# CITY OF ALBUQUERQUE

**Re:** A-Tech Security  
**4616 Hawkins NE**  
**Traffic Circulation Layout**  
Engineer's Stamp dated 07-07-16 (D17D104)

**Re: A-Tech Security  
4616 Hawkins St., NE  
Traffic Circulation Layout  
Engineer's/Architect's Stamp dated 5-25-16 (D17-D104)**

**Re: Nelson-Hawkins Lot #16-A(1)**  
**4616 Hawkins St., NE**  
**Traffic Circulation Layout**  
Engineer's/Architect's Stamp dated 11-16-15 (D17-D104)

CHECKED BY: PWC DATE: 5/27/16 FILE #: TOL 1 OF 1

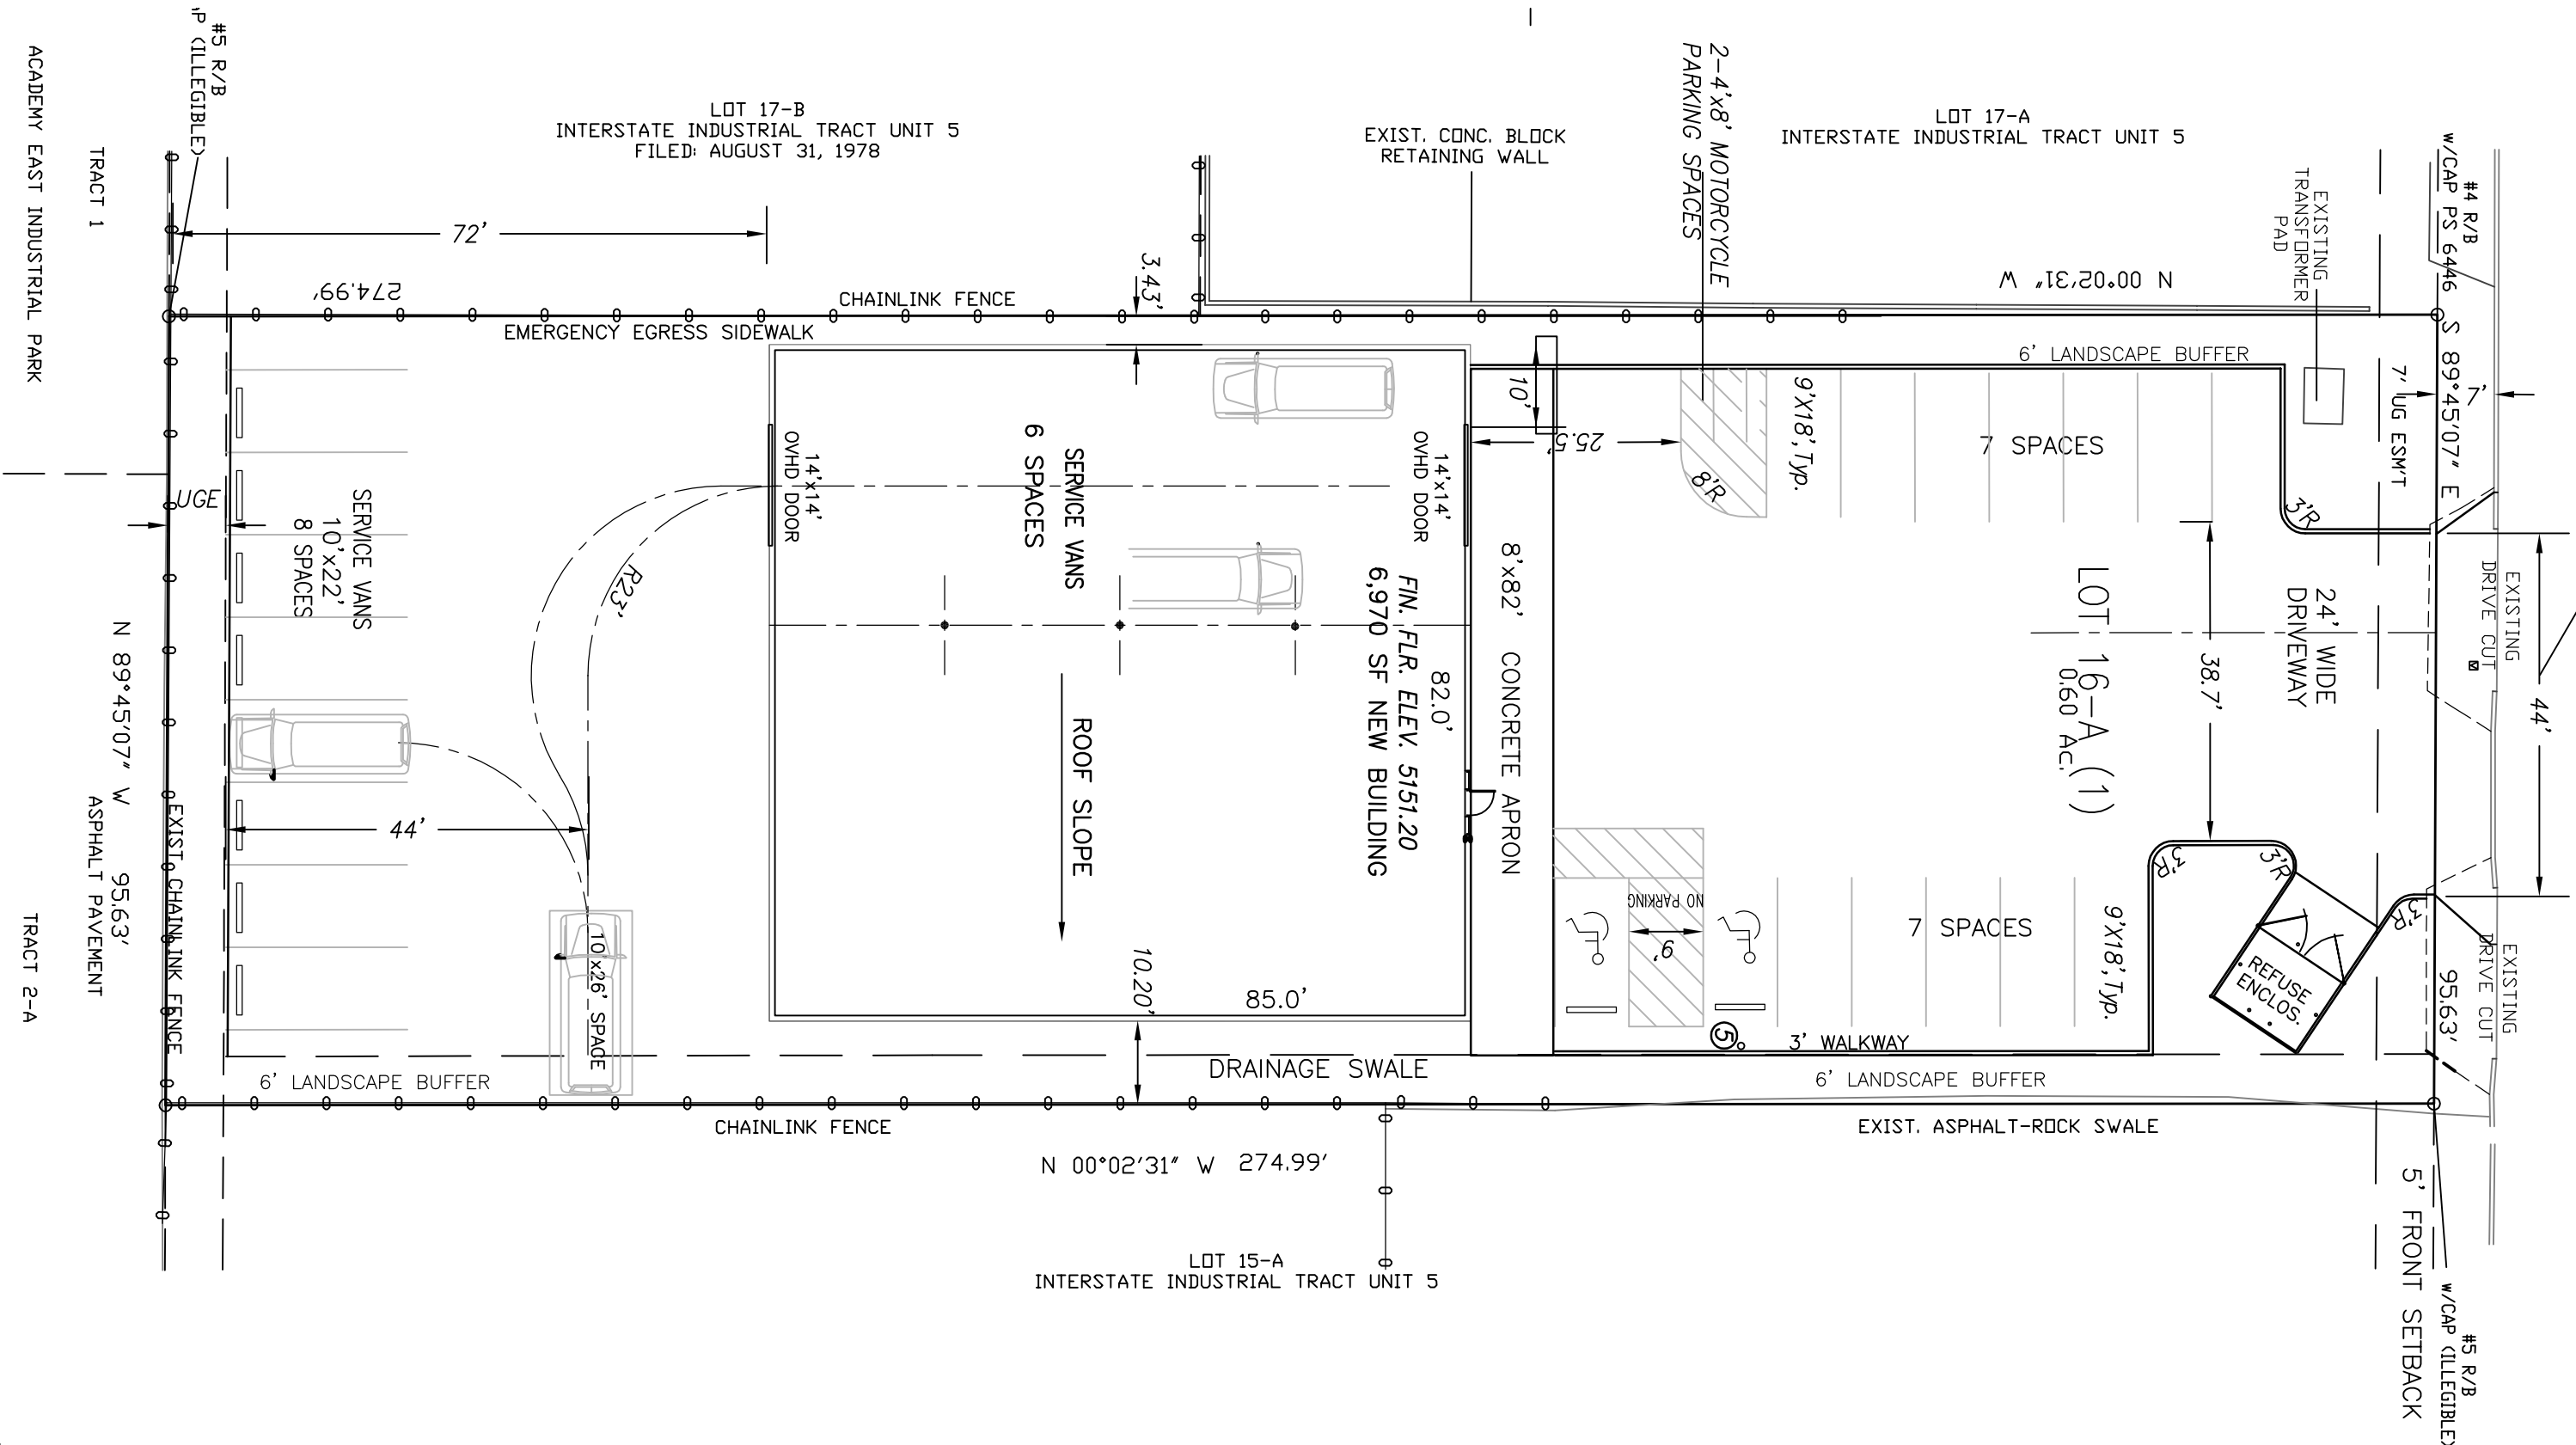
1. Please state the type of material to be used for the parking lot on the south end of the project site.
2. Per the DPM, a 6 ft. wide ADA accessible pedestrian pathway is required from the public sidewalk to the building entrances. Please clearly show this pathway and provide details from Hawkins St. Provide detail of ADA ramp from public R.O.W.

3. Per the DPM, a 6 ft. wide ADA accessible pedestrian pathway is required from the HC parking stall access aisles to the building entrances. Please clearly show this pathway to the building entrance. The ADA path must not have pedestrians crossing behind parking spaces. Please reconfigure pathway to the east of the HC parking spaces.

4. Provide a min 6" or max 8" high concrete barrier curb or other acceptable barrier between landscaping and parking areas and/or drive aisles.
5. Service vehicle and/or refuse vehicle maneuvering must be contained on-site; provide a copy of refuse approval.

6. Please add signage stating that parking in the bay and on south end of building is for employees only.

7. Please provide a sight distance exhibit (see the *Development Process Manual, Chapter 23, Section 3*). Please show this detail for the entrance/exit on Hawkins St.

8. Unused curb cuts must be replaced with sidewalk and curb & gutter. A build note must be provided referring to the appropriate City Standard drawing.
9. Please include two copies of the traffic circulation layout at the next submittal.
